MMC Parking Garage - Final Traffic Comments

From: **Tom Errico** <thomas.errico@tylin.com>
Date: Tue, Aug 14, 2018 at 9:20 AM
Subject: MMC Parking Garage - Final Traffic Comments
To: Helen Donaldson <HCD@portlandmaine.gov>
Cc: Bruce Hyman <bhyman@portlandmaine.gov>, Jeremiah Bartlett <JBartlett@portlandmaine.gov>

Hi Nell – I have conducted comprehensive review of current application materials and offer the following final traffic comments as a status update of prior comments.

PHASE 1 LOGISTICS PLAN SEPTEMBER 2018 - SUMMER 2019

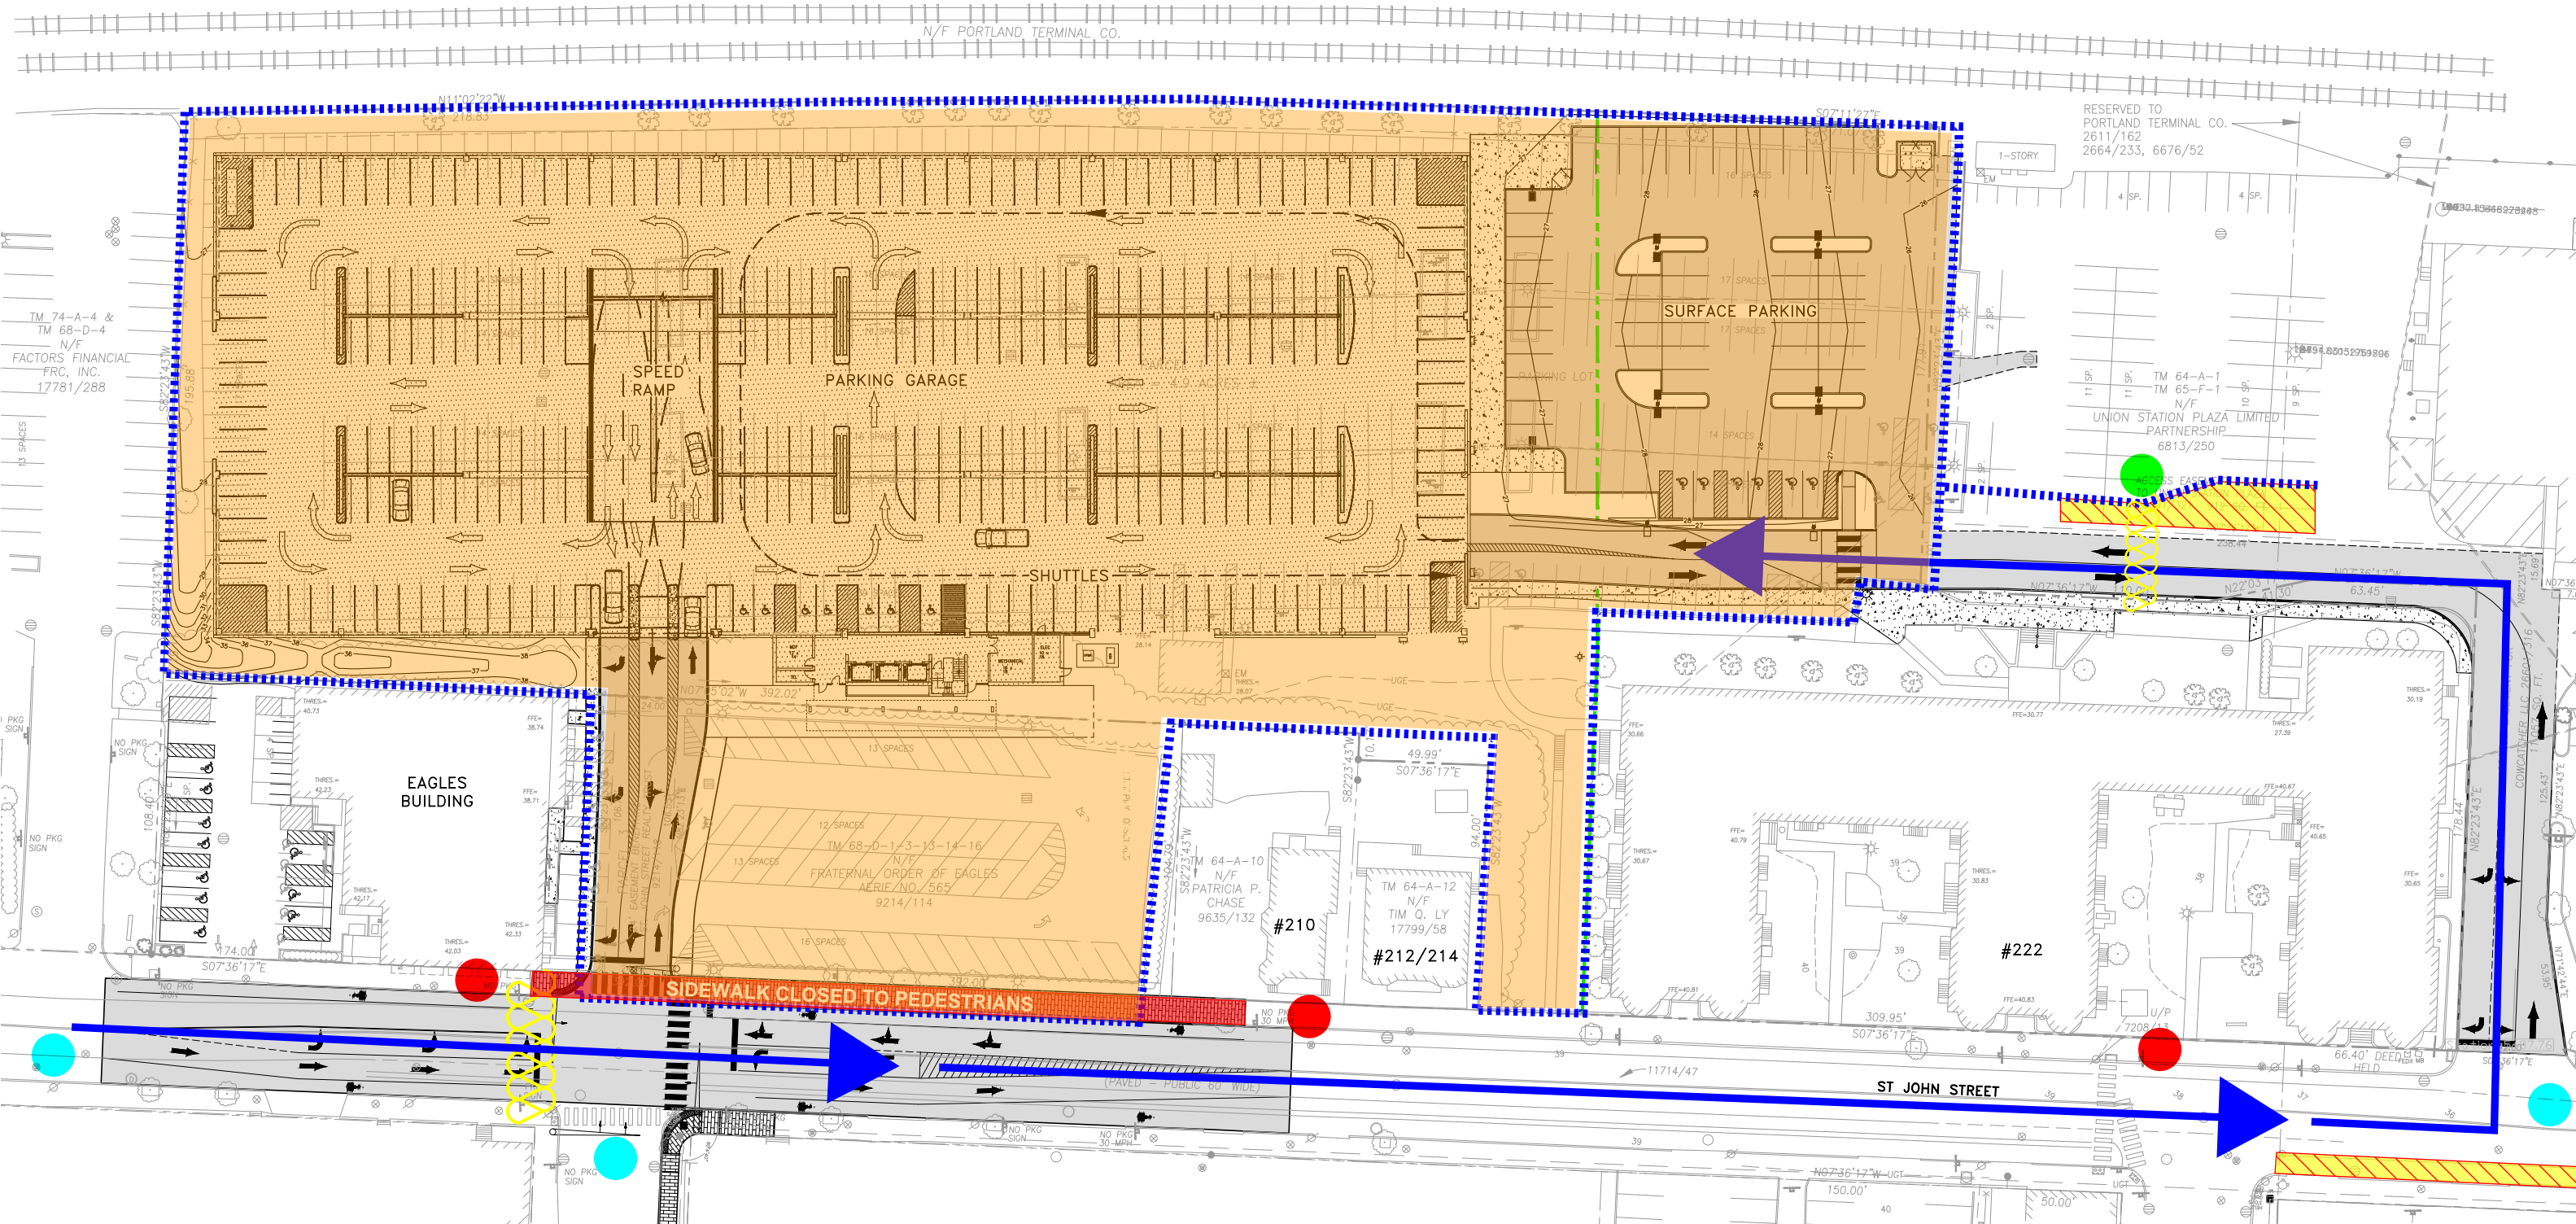
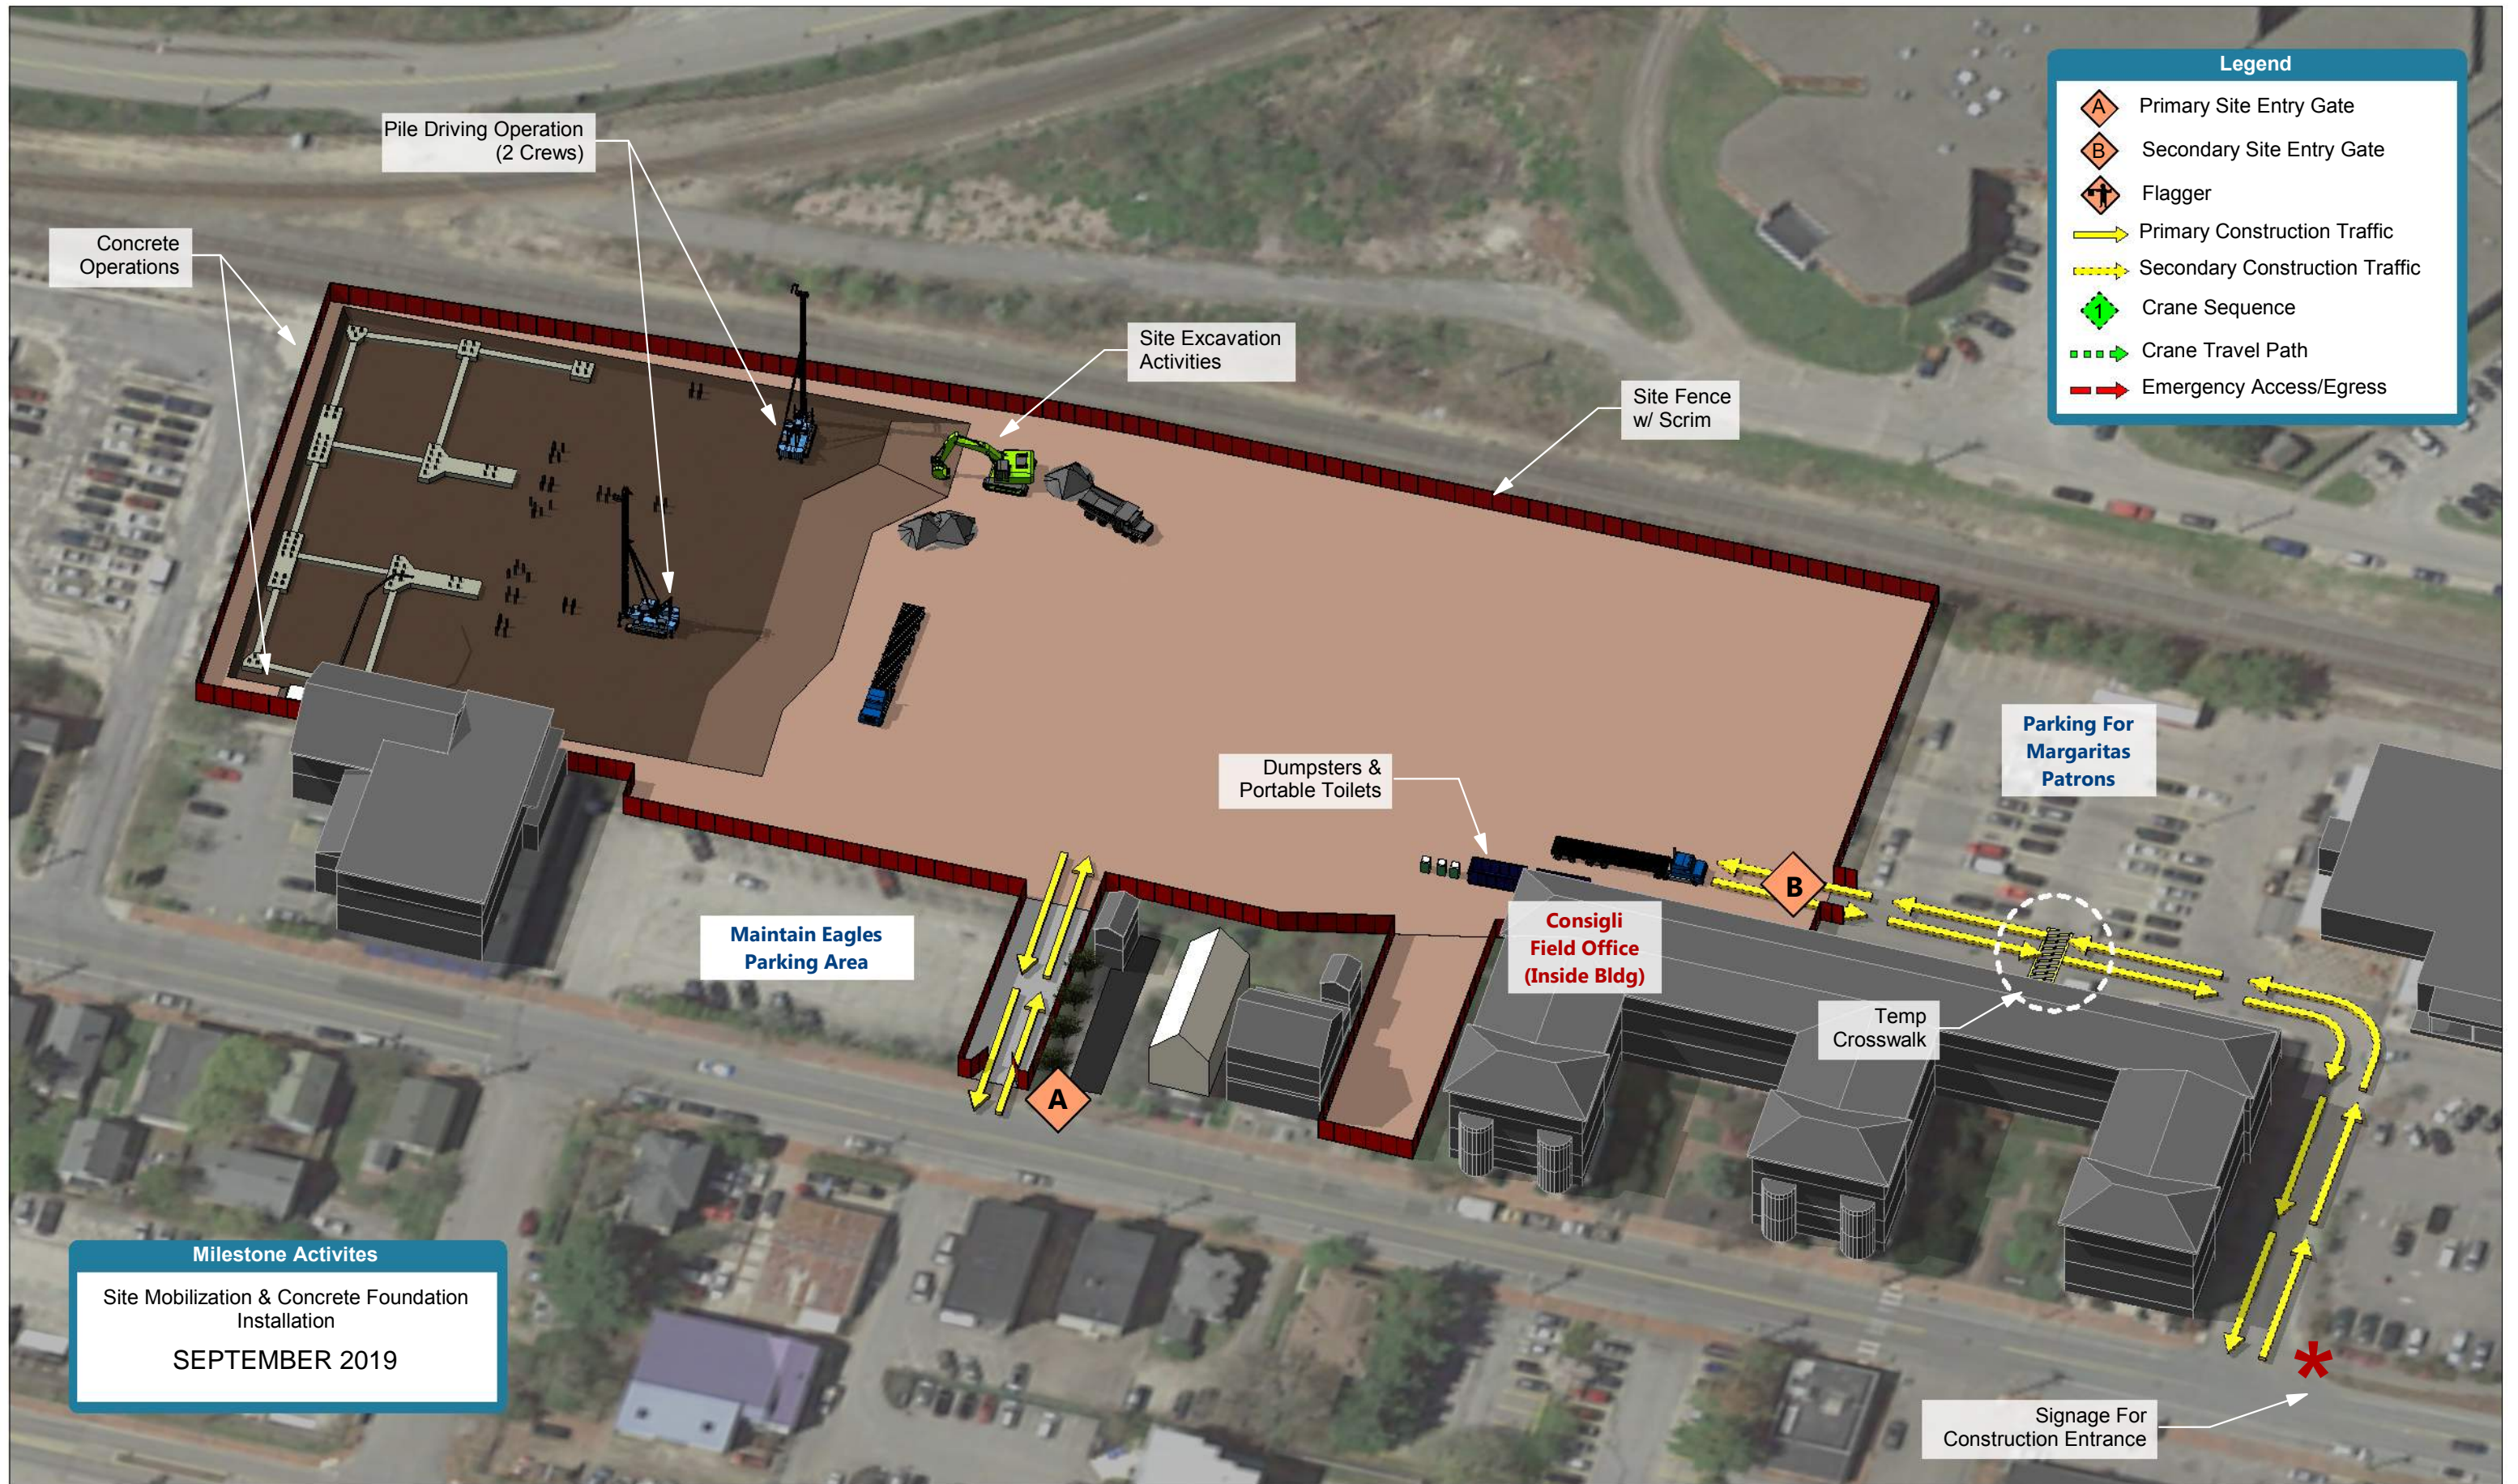
- **Construction Management Plan**
 - **Construction trucks time limits shall be extended to include both MMC and general traffic peak hours.**
 - **The secondary storage yard shall be specifically identified.**
 - **The applicant should note how will the Eagles parking demand be accommodated during construction.**
 - **All temporary crosswalks shall be ADA compliant.**
 - **Construction plans shall be provided for the roadway/signal work in St. John Street, D Street, and Valley Street.**
- **The applicant shall narrow the Eagles driveway width to match the aisle width.**
- **The Eagles existing parking lot shall provide an aisle width dimension.**
- **The applicant shall provide the grade of parking ramps within the garage.**
